Your Ref:
Our Ref: FP/217/08/
Please ask for:
Mrs S Leeson

18th November 2008

Conversion and change of use of existing residential care home to 4 no private flats
(Resubmission of FP/99/08)
4 Felpham Road Bognor Regis

Drawing	Scale	Date	Drawing No.
LOCATION PLAN	1:200; 1250	OCT 08	9270/PL2/01
SITE/BLOCK PLAN

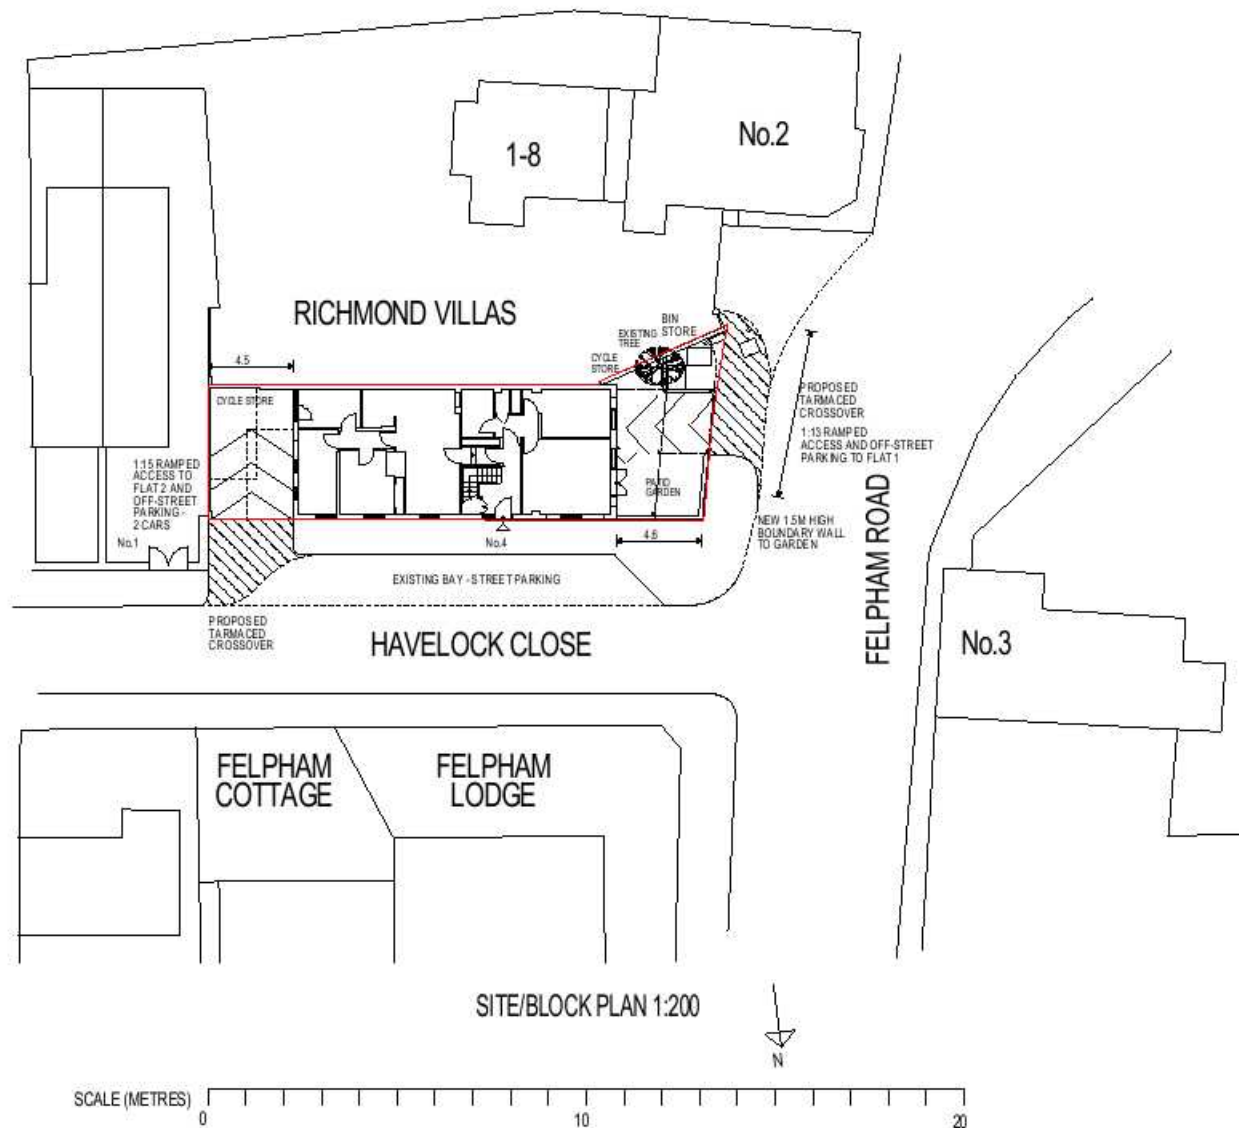
Committee objected to this planning application on the same grounds as the previous application (FP/99/08) namely concern regarding vehicle access and exits from the car parking spaces adjacent to a busy and dangerous bend on the road.
